CITY OF ALBUQUERQUE

August 27, 2019

**RE: Stone Age Climbing Gym
6200 Alameda NE
Grading & Drainage Plan and Drainage Report
Engineer's Stamp Date: 08/19/19
Hydrology File: C18D086A**

grading and
drainage plan

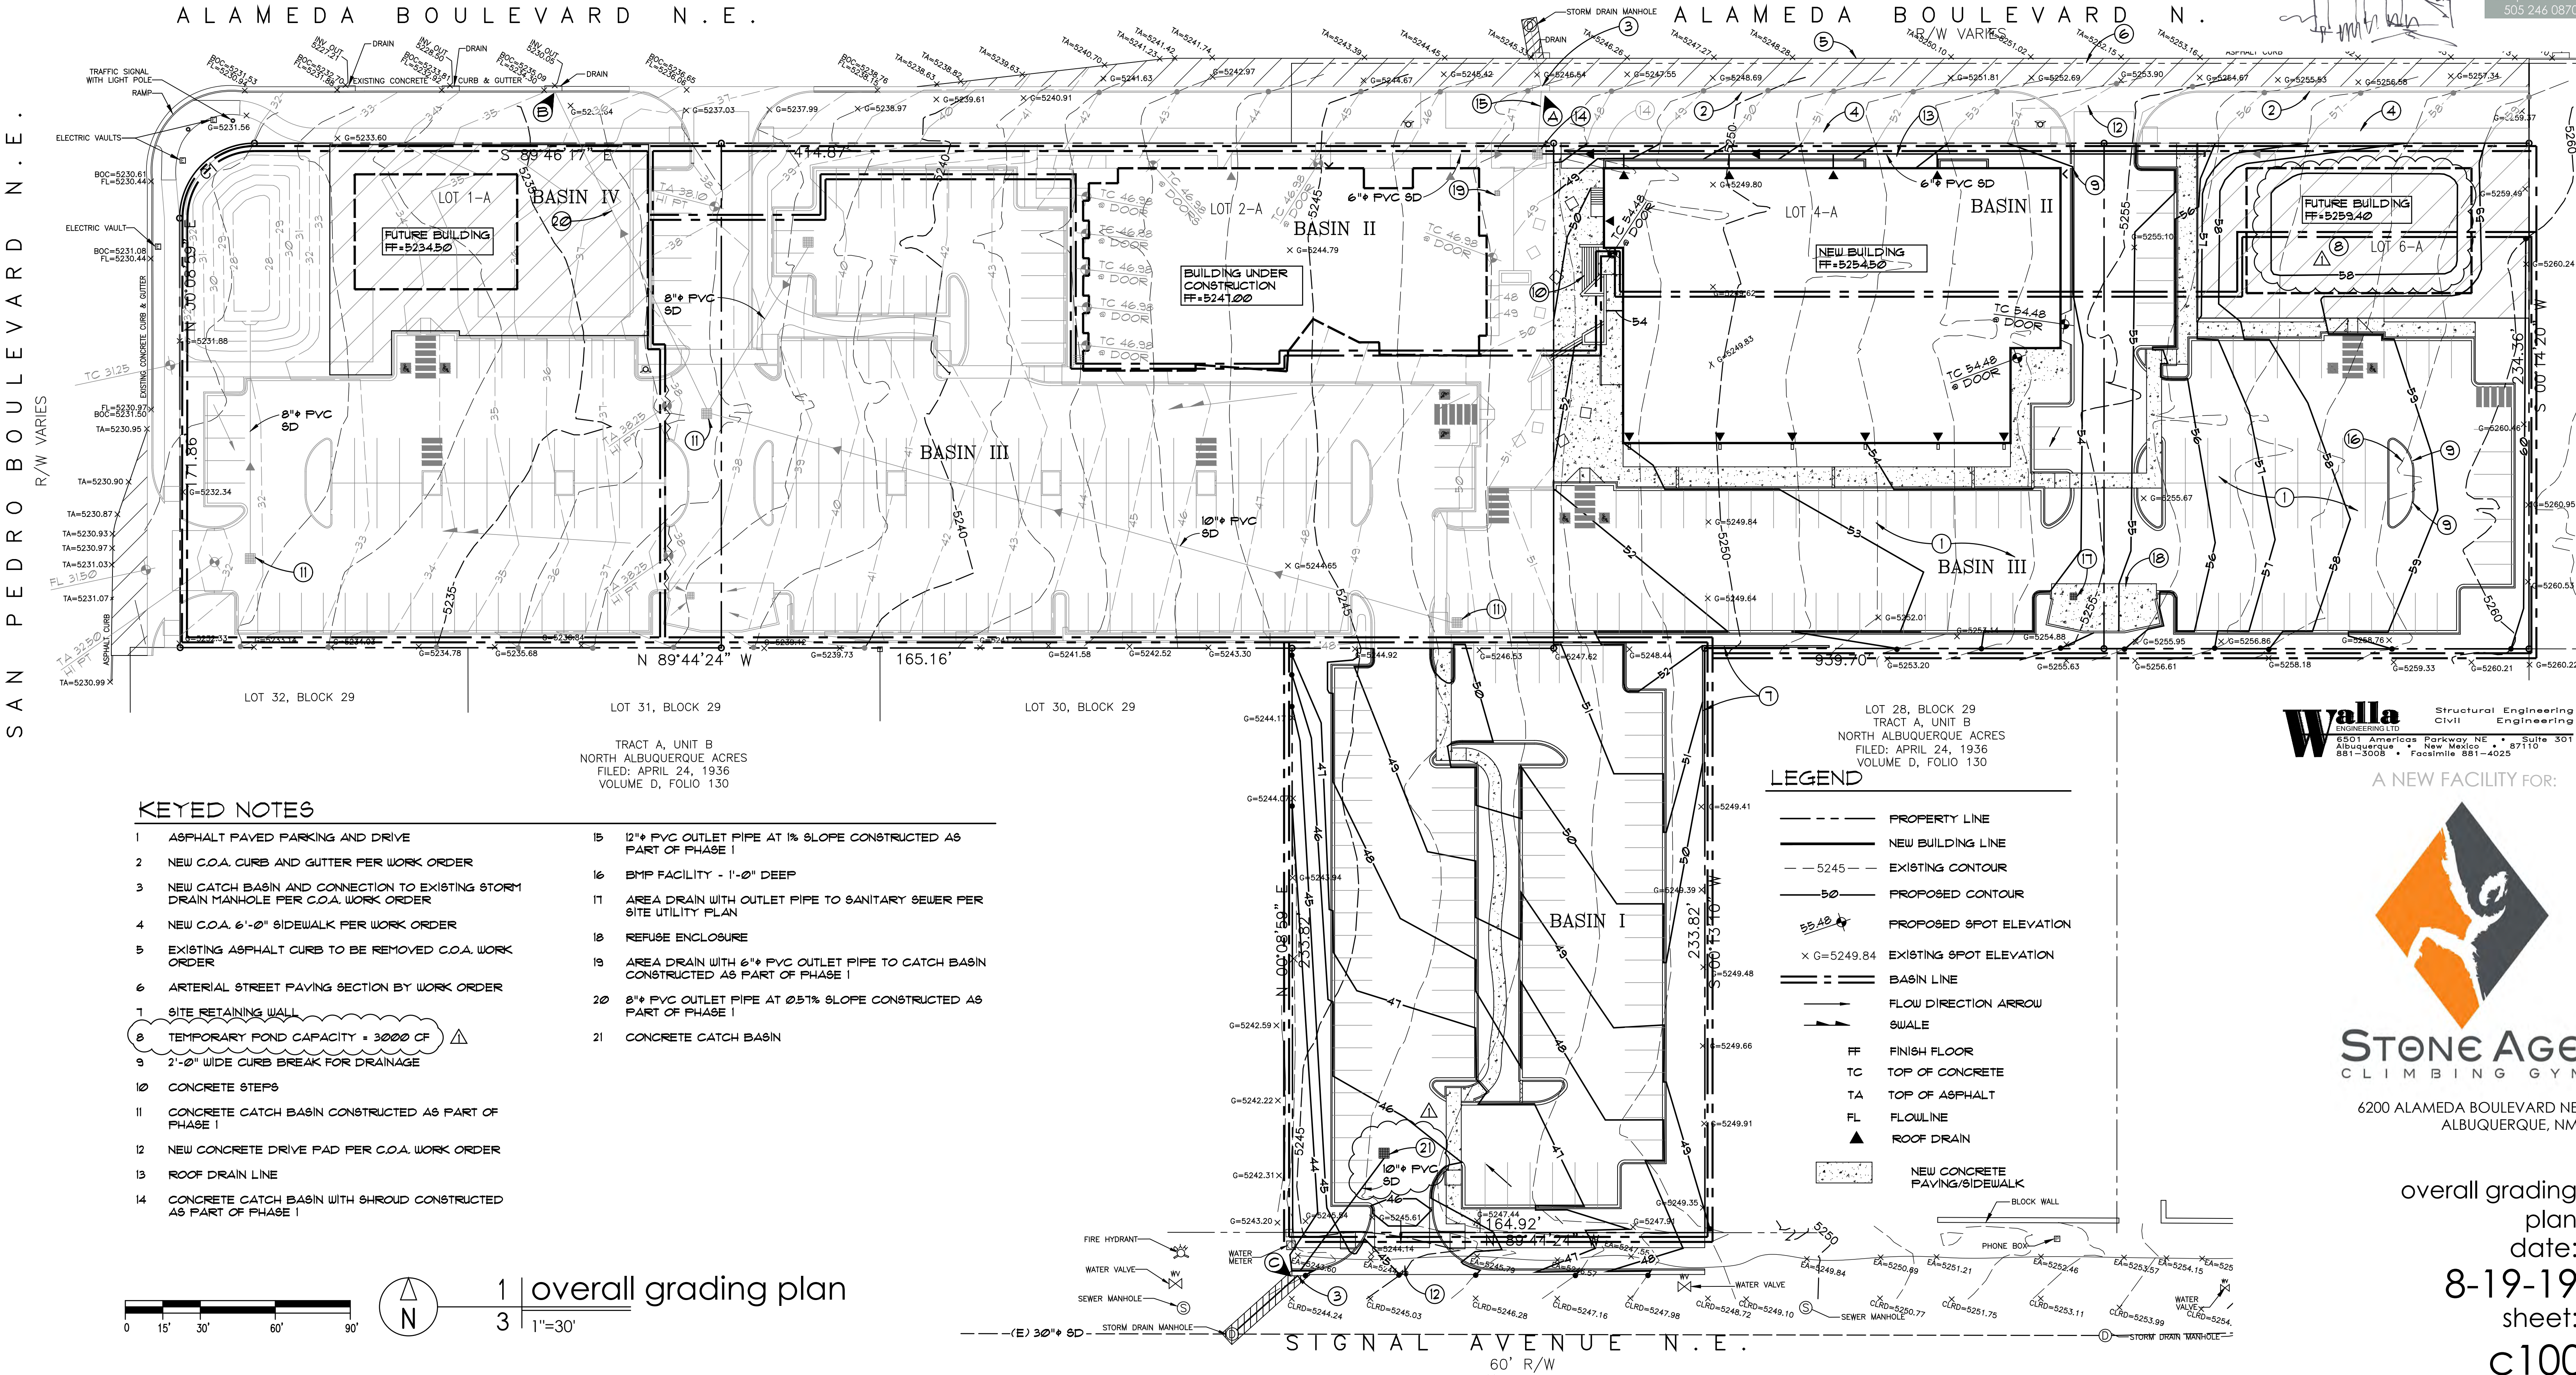
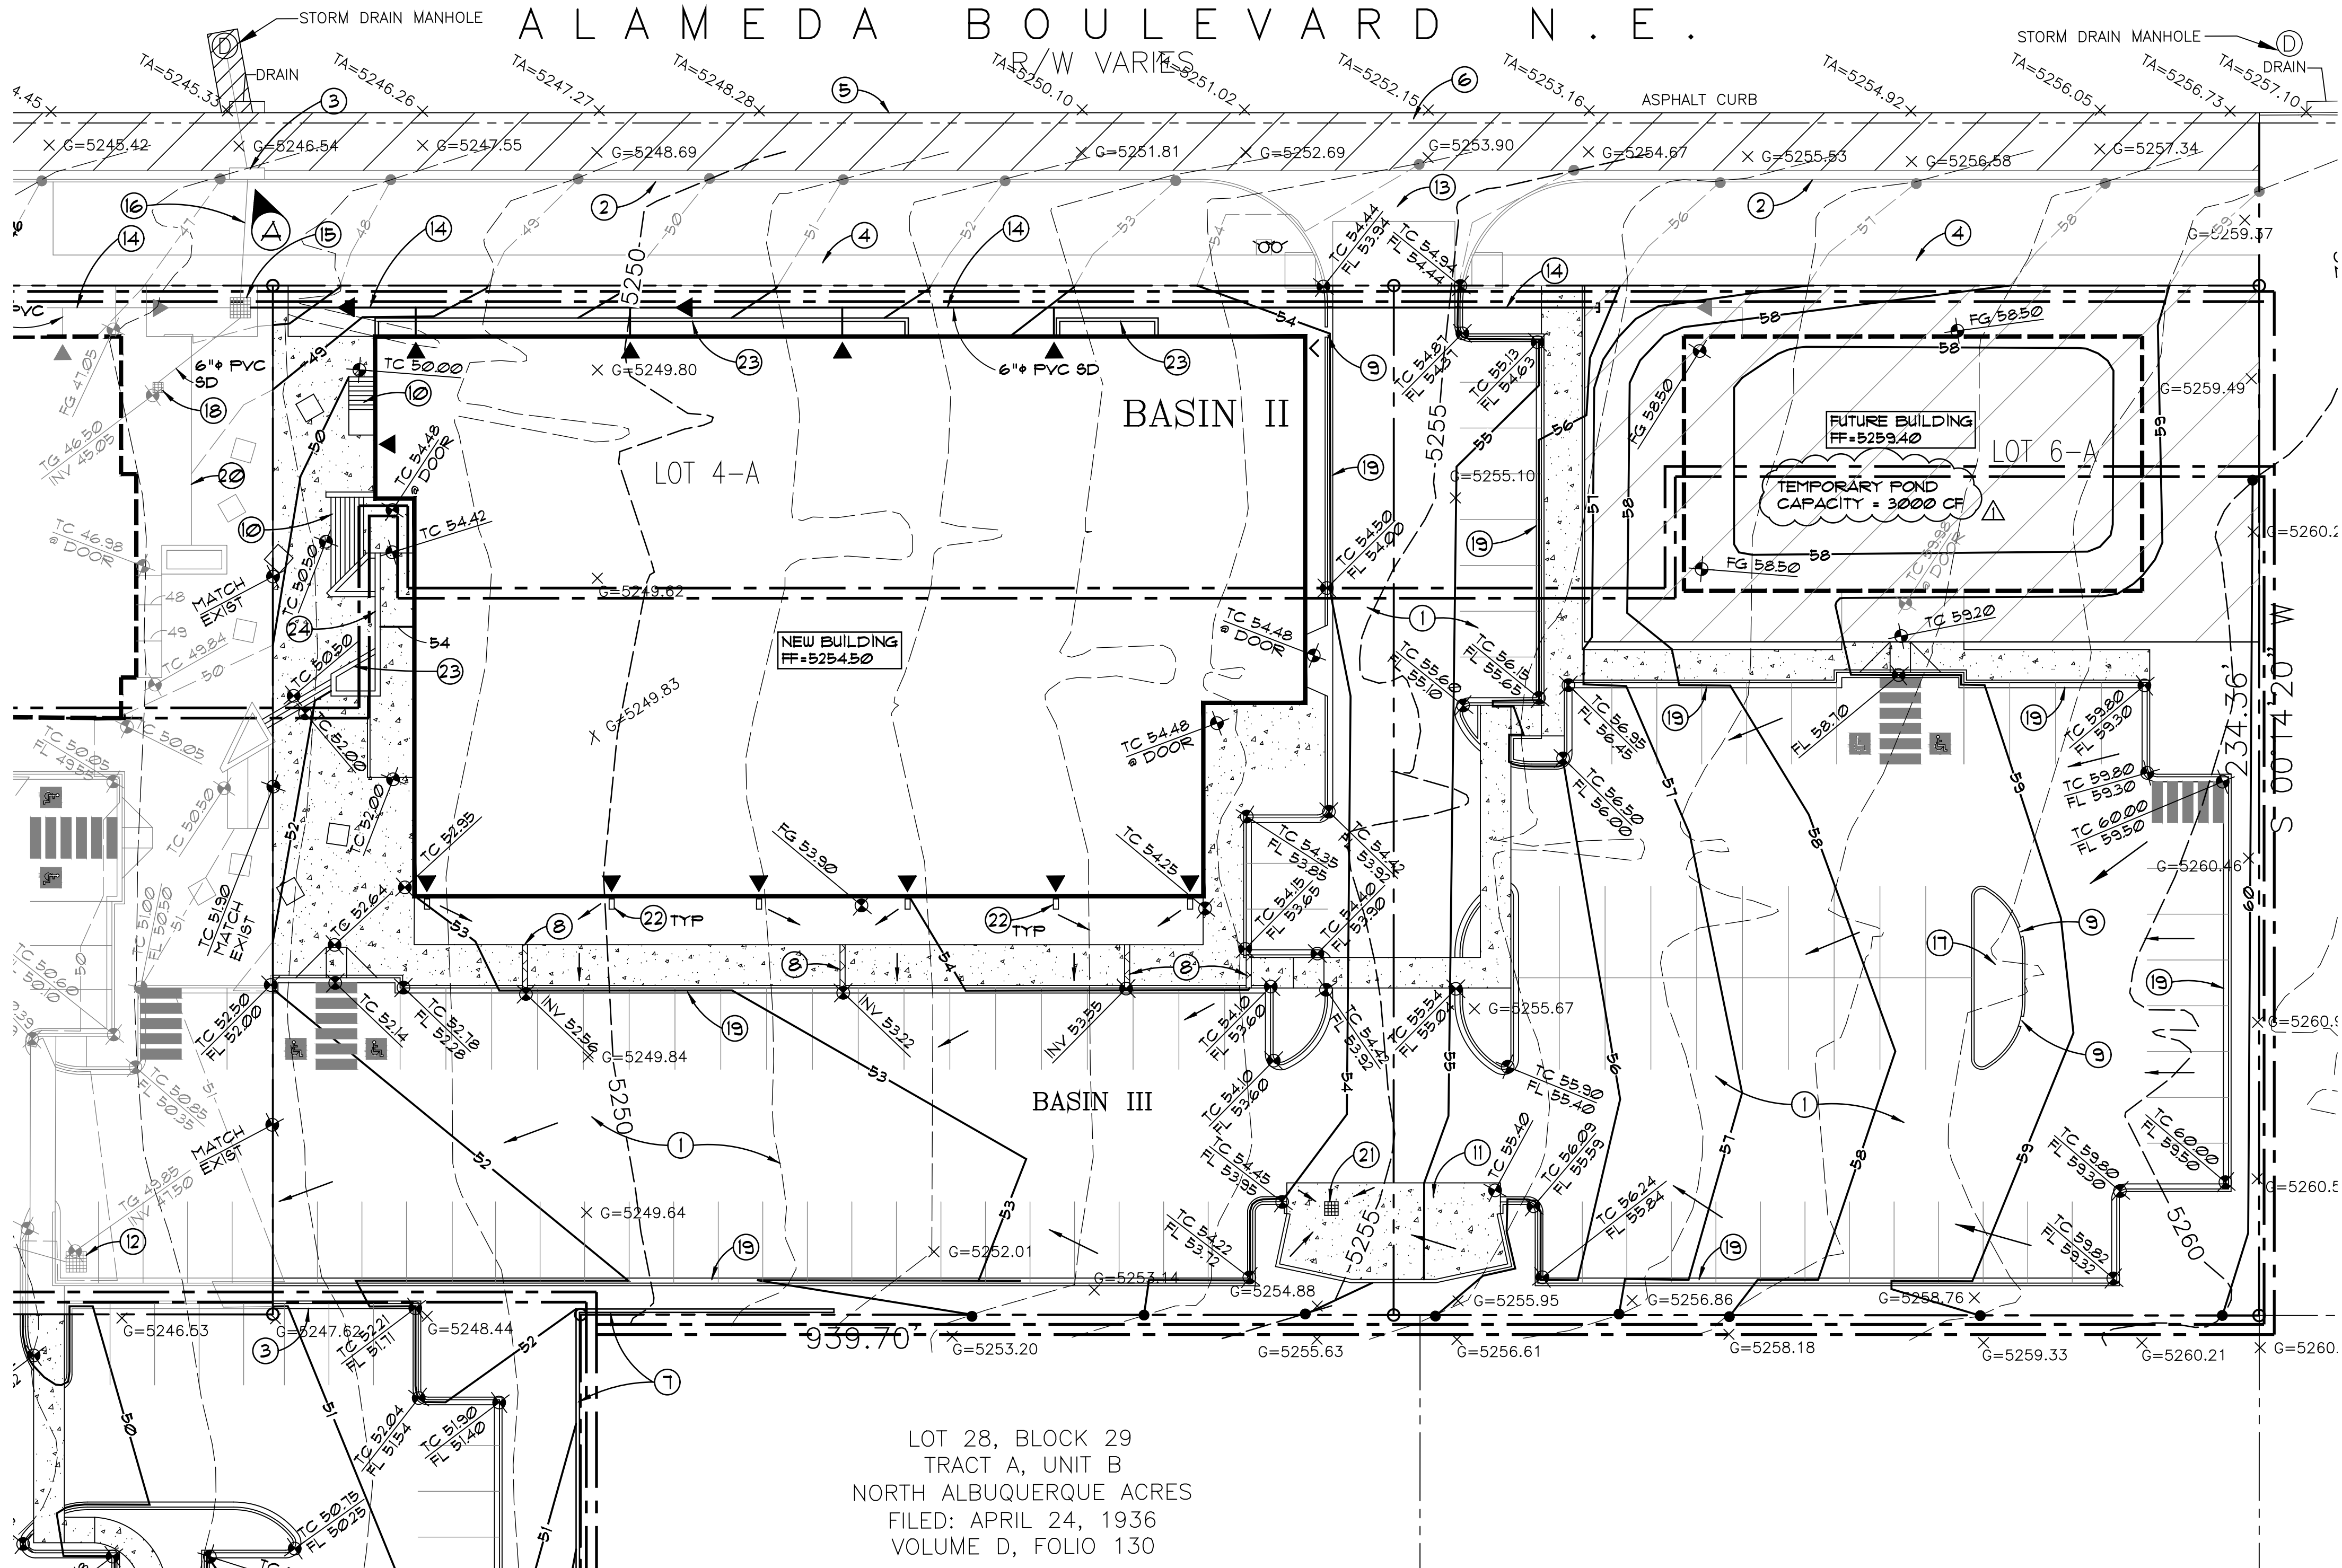
1. Grading & Drainage Plans. There is a temporary retention pond at the area of a future building near the northeast corner of the development. I do not see any purpose for the retention pond. There will be no drainage going into this pond. This area should just be graded for the future pad of the building.

2. Grading & Drainage Plan. Under the Drainage Points, "C" should be 4.02 cfs. This will match the drainage for Basin I in the Ultimate Development.
3. Grading & Drainage Plan. The proposed grate in Basin I is too high and needs to be at the southwest corner of the parking lot. This location is where all the drainage from Basin I is flowing towards. By leaving the inlet as shown, there will be pool of water collecting at the southwest corner of the parking lot. Please fix.
